**M42 Junction 6 Improvement
Scheme Number TR010027
Volume 6**

Appendix 5.3 – EIA scoping opinion: response table

Planning Inspectorate Scoping Opinion

Appendix 1
Asset Plan

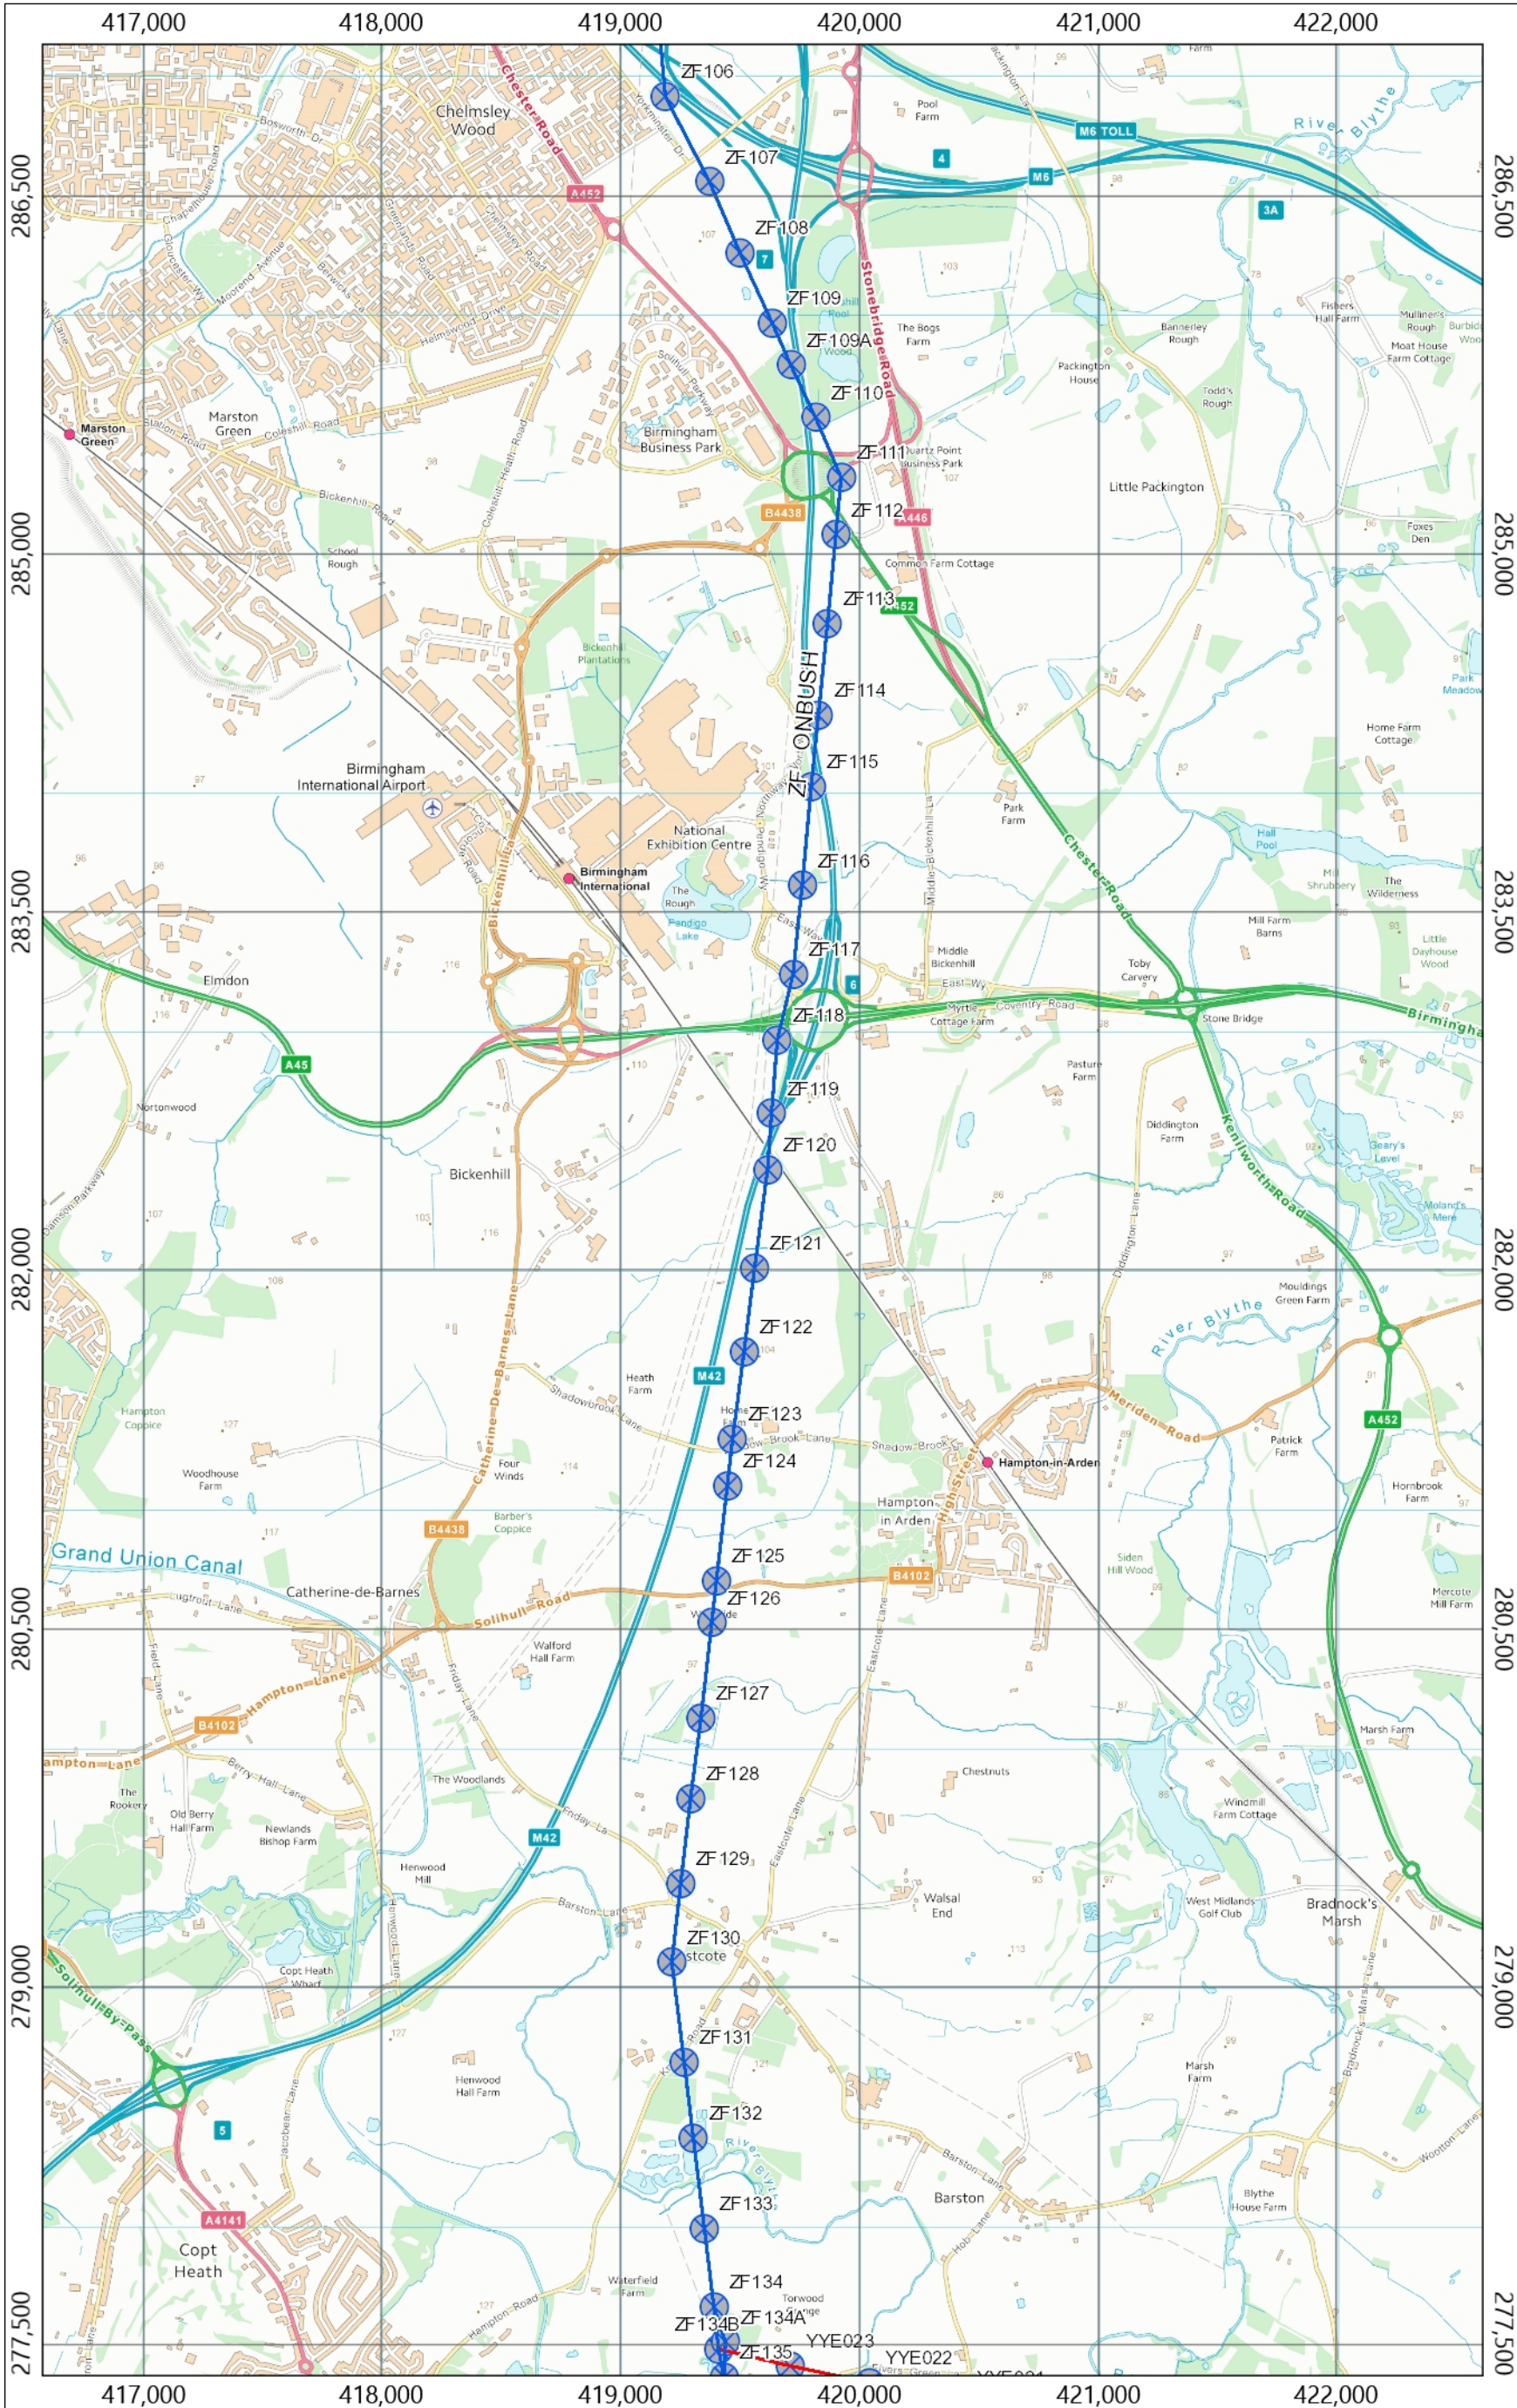
All Assessments	<p>National Grid, in their scoping consultation response, have supplied plans showing where high voltage electricity overhead transmission lines exist in the vicinity of the Proposed development. In addition, Cadent Gas Limited, in their scoping</p>	3.3.5	<p>The form and location of existing utilities and their relationship to the Scheme have principally been taken account of in the design-development process, the objective</p>	<p>Chapter 3 The project [TR010027/APP/6.1]</p> <p>Chapter 5 EIA Methodology and consultation [TR010027/APP/6.1]</p>

Topic or aspect	Comment	Scoping opinion reference	Response to scoping opinion	Where covered in the Environmental Statement (or in other application documents)
	consultation response, have supplied plans showing where gas pipelines and equipment are present. The Applicant should take the location of these assets into account in relevant assessments to the ES.		being to avoid potential effects on, or conflicts with, this infrastructure. Cognisance has been given to utilities within the EIA methodology and consultation chapter within the Environmental Statement.	
Limitations and Assumptions	The ES should include details of difficulties (for example technical deficiencies or lack of knowledge) encountered compiling the required information and the main uncertainties involved. The ES should also identify where assumptions have been made with respect to any modelling carried out, for example the traffic modelling, and the implications for the outcome of the assessments.	3.3.6	Uncertainty, technical deficiencies and lack of knowledge have been encountered during the Environmental Impact Assessment. Where these have placed limitations on the assessments undertaken or have necessitated the adoption of assumptions, this has been described within the topic-specific assessments reported in the	Chapter 5 EIA Methodology and consultation [TR010027/APP/6.1] Chapters 6 – 15 (technical assessments) [TR010027/APP/6.1] Chapter 16 Assessment of cumulative effects [TR010027/APP/6.1]
